In relation to the above application, I have now reviewed the following documents:

- Soils Ltd. Phase I Desk study (ref.: 17028/DS, dated November 2016)
- Soils Ltd. Compiled Ground Investigation Report (ref.: 17403/CGIR, dated February 2019)
- Soils Ltd. Soil Gas Risk Assessment (ref.: 17403/SGRA, dated April 2019)

Whilst the majority of the submissions are considered satisfactory, I have please two queries which are outlined below for ease of reference:

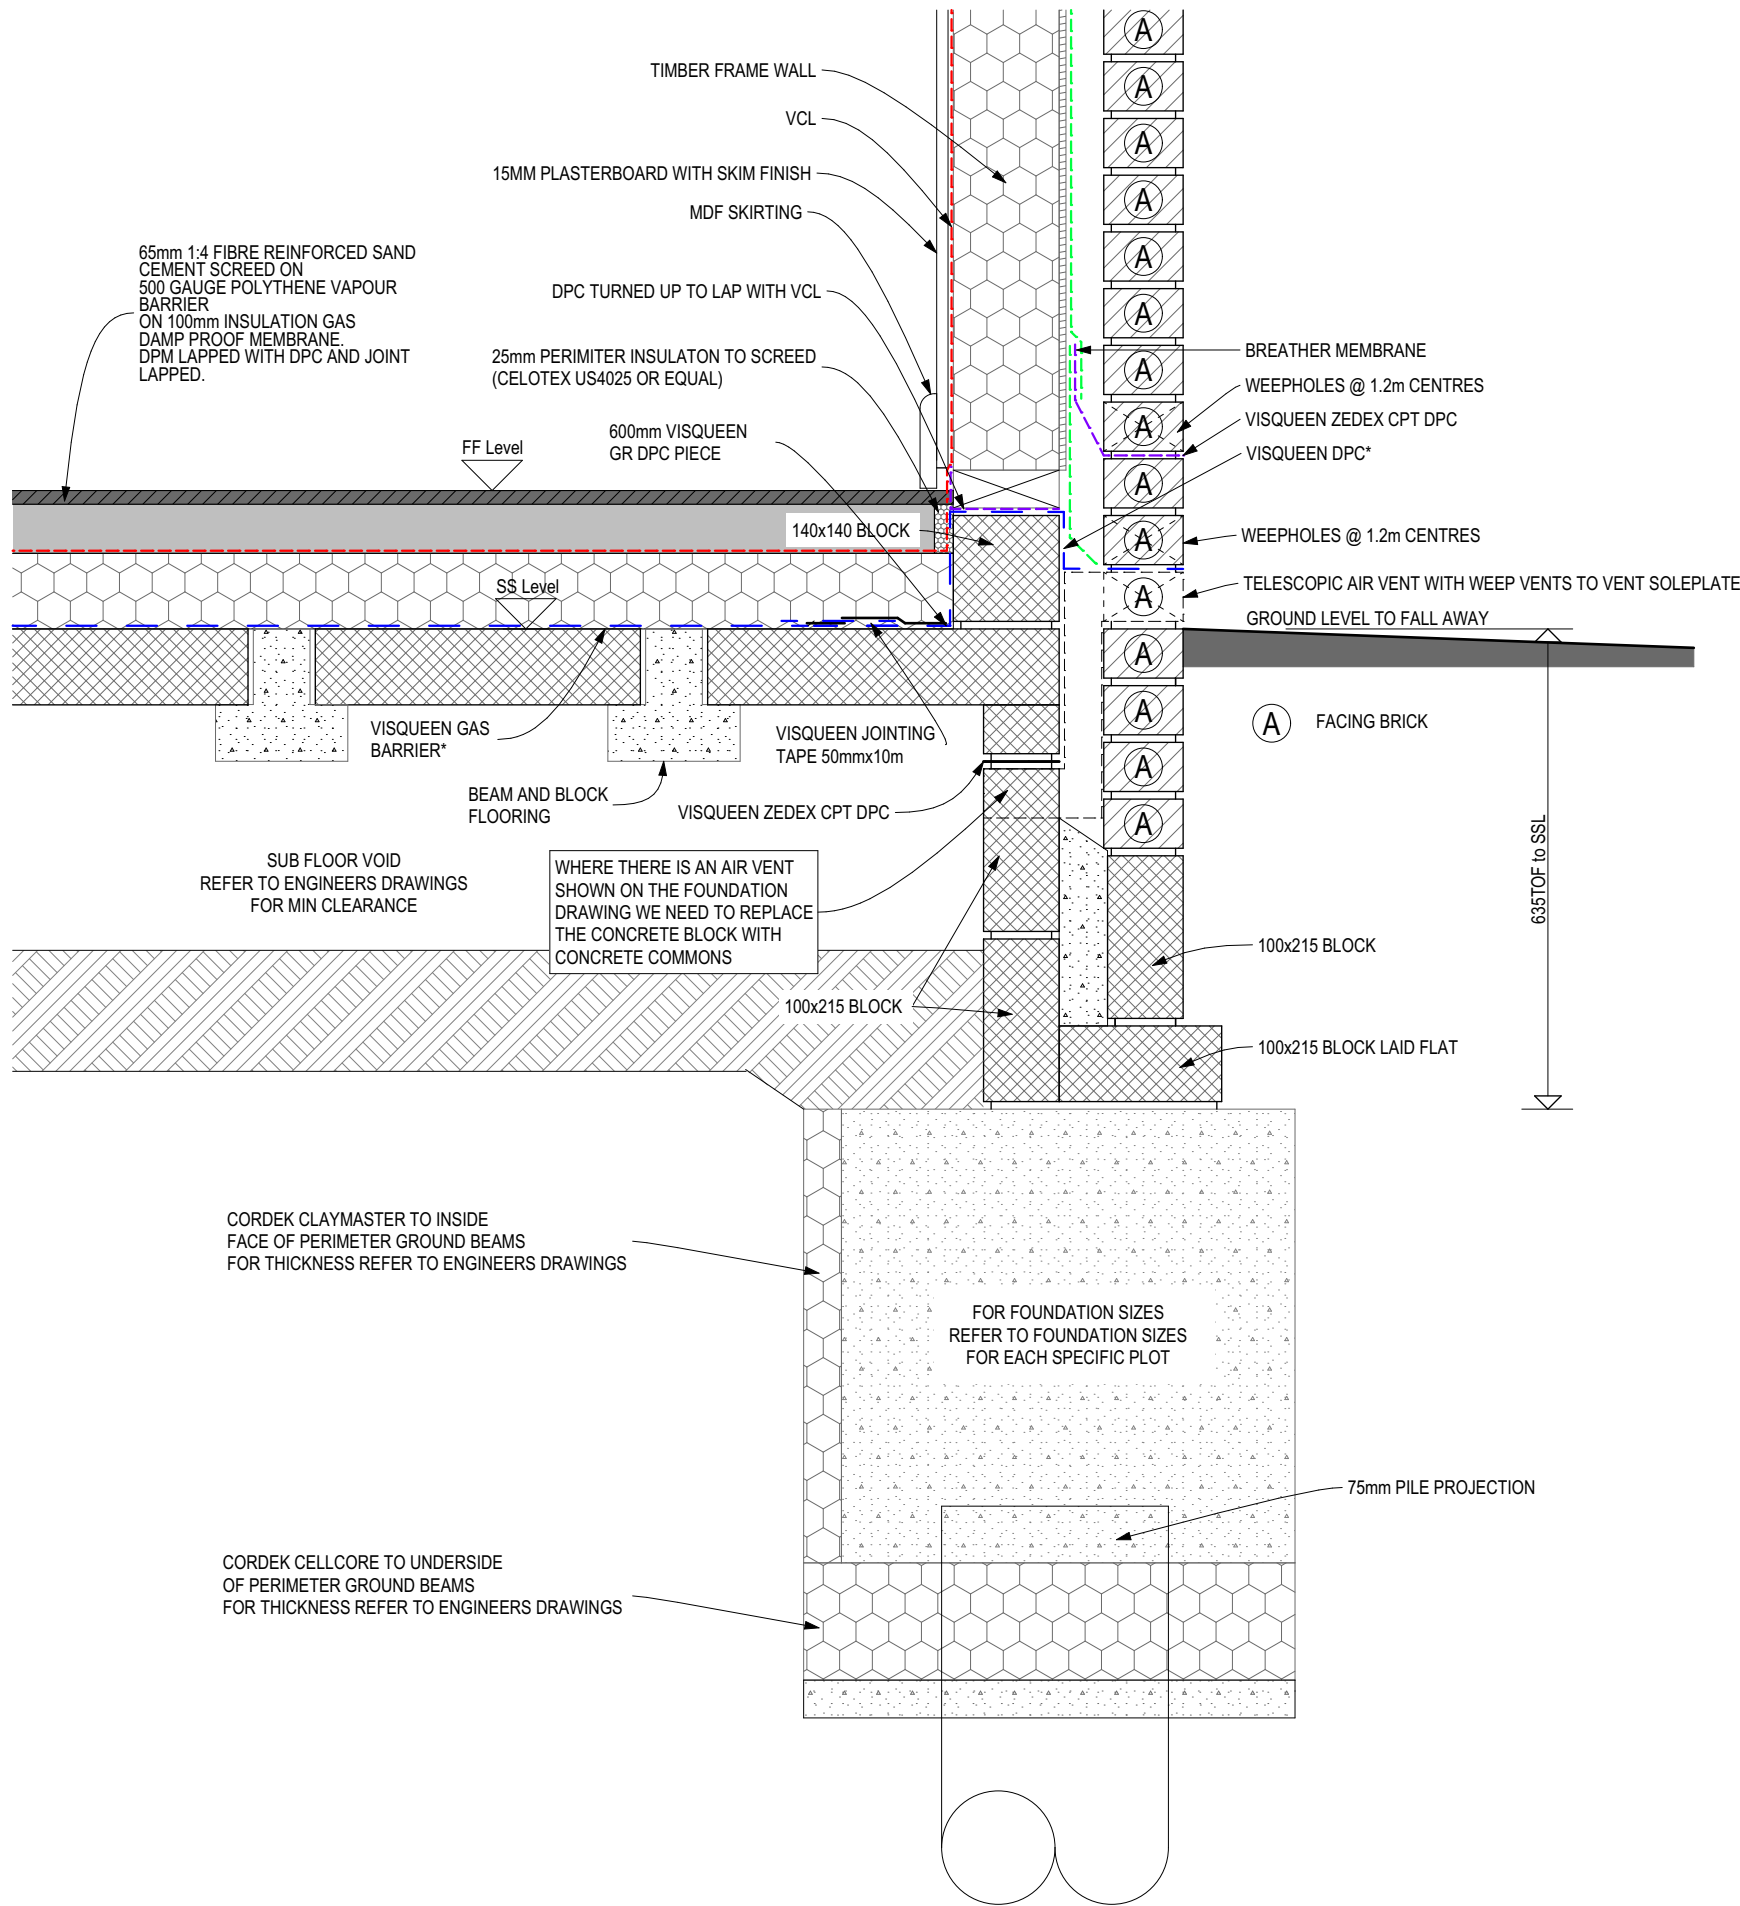
- the CGIR identified an exceedance of lead at 0.10 metres depth and stated that based on the proposed development plan, no remediation was required, however no management of this exceedance is mentioned and no subsequent sampling of the garden areas was undertaken;
- the SGRA concludes that gas protection measures are likely to be required, however no detail is provided.
